WELWYN HATFIELD COUNCIL – DEVELOPMENT CONTROL
DELEGATED REPORT

APPLICATION No:	W6/2011/0367/EM
------------------------	------------------------

This application seeks consent for the erection of a single storey rear extension and extension to the garage.

Proposed Extensions. Construction materials to match existing dwelling.
Proposed rear elevation.

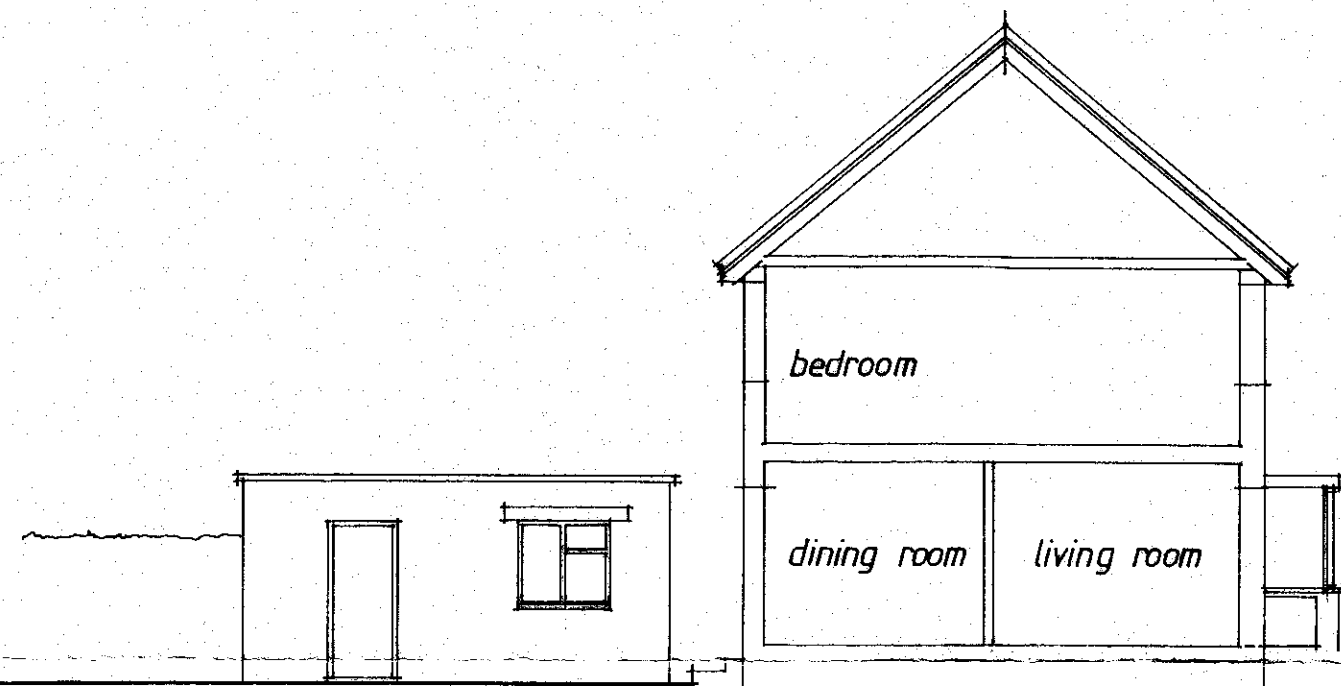
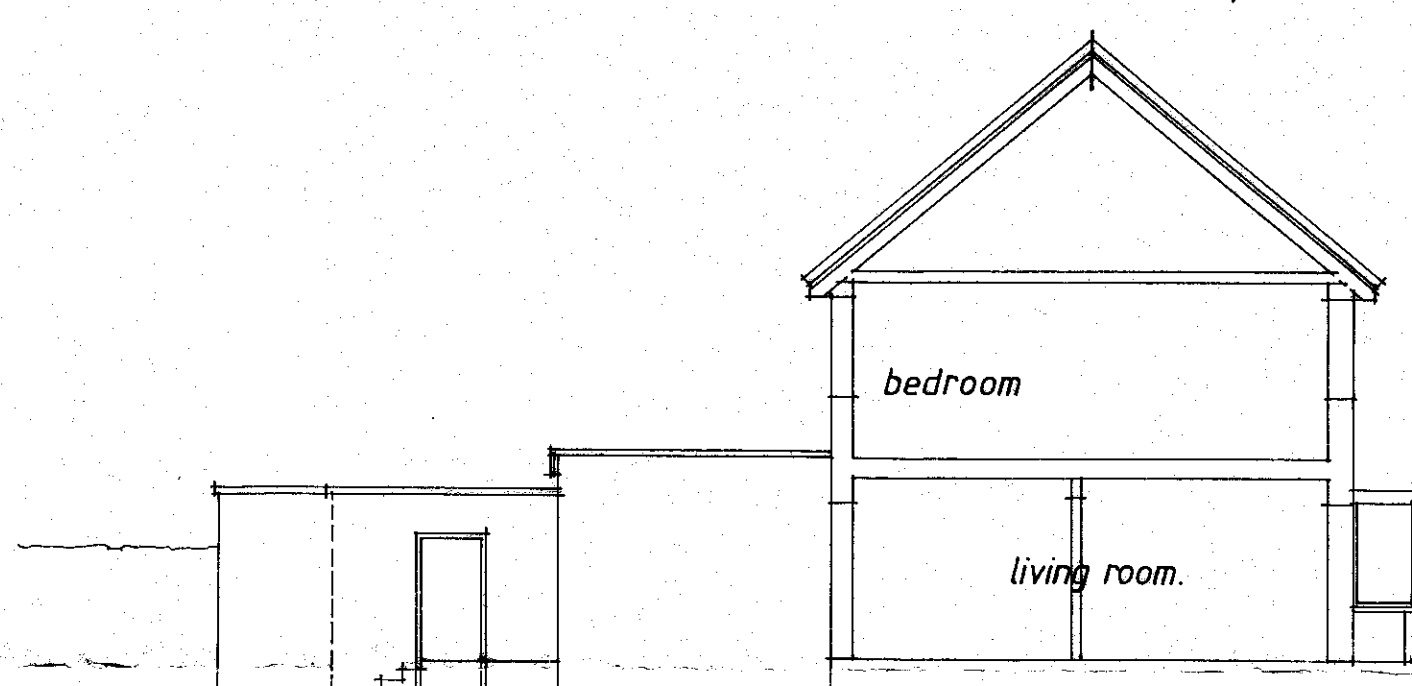
The proposed extensions would increase the mass and bulk of the existing property, however they would be designed with a flat roof which is characteristic of the garden city which would help to reduce the overall bulk and scale of the extension. They would both be subordinate to the original property. Additionally both extensions would be to the rear of the property and would not be visible from a public view point. An adequate level of amenity space would also be retained for the occupiers of the dwelling.

In relation to the detailed design and appearance of the extension it is considered that the architectural detailing of the original property would be reflected within the proposed extensions where the fenestration would reflect the fenestration of the existing dwelling and surrounding properties. The flat roof of the extension would be characteristic of the garden city. The materials to be used in the development would match the existing property and garage, however a condition would be placed on any consent to ensure this.

Turning to the loss of the existing chimney, this is sited to the rear of the property and does not extend above the ridge of the property and subsequently it is not unduly visible from the road frontage of Rooks Hill. Whilst a number of other properties to the rear have chimneys, the visual impact of its removal would therefore not be overly significant, given that it is located in an unduly prominent position on the roof slope. It is considered that its removal would not interrupt the pattern of symmetry within these properties and consequently would not be out of keeping with the design, appearance and architectural dwelling. The aim of the Estate Management Scheme is to ensure that the dwellings and street scene are kept in harmony with the original design and concept of the town. It is therefore considered that the removal of the chimney would not deviate from the original integrity and character of the building, and would not reflect negatively on the values and amenities of the area.

Proposed ground floor plan.

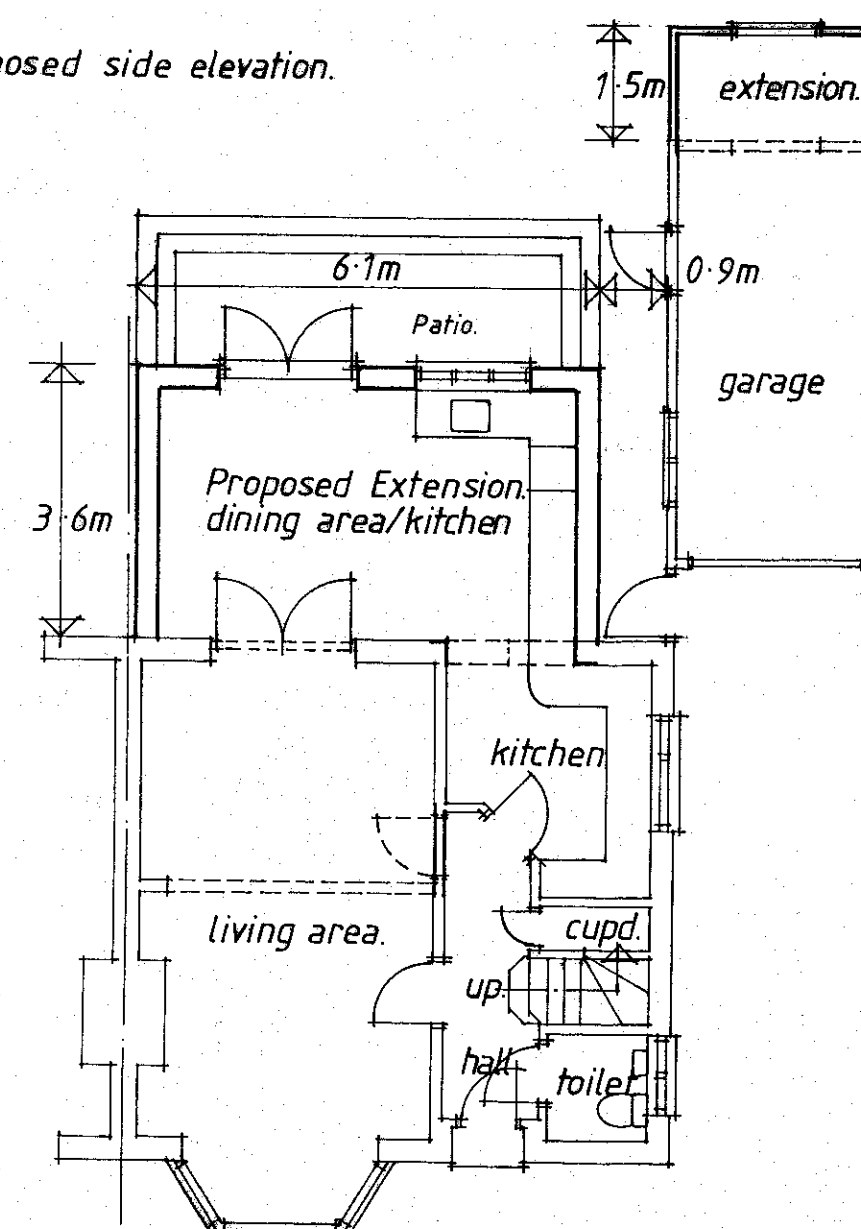
The proposed extension to the dwelling would have a depth of 3.6m and be alongside the common boundary of No. 24 Rooks Hill, which has not been extended to the rear. No. 24 has the same layout as the application property with patio doors nearest the application property. As a result of the proposed depth of the development, together with its overall height at about 3.2 metres, it is considered that the proposed development would not give rise to an unacceptable overbearing or dominant impact on this, or other properties. With the relevant siting of the proposed development together with its overall height, it is considered that any reduction in light would be very limited and would not be cause a detrimental impact to the occupiers of this dwelling. In addition, this extension is considered to be a reasonable distance from No. 20 to cause no impact to the residential amenity that they currently enjoy.
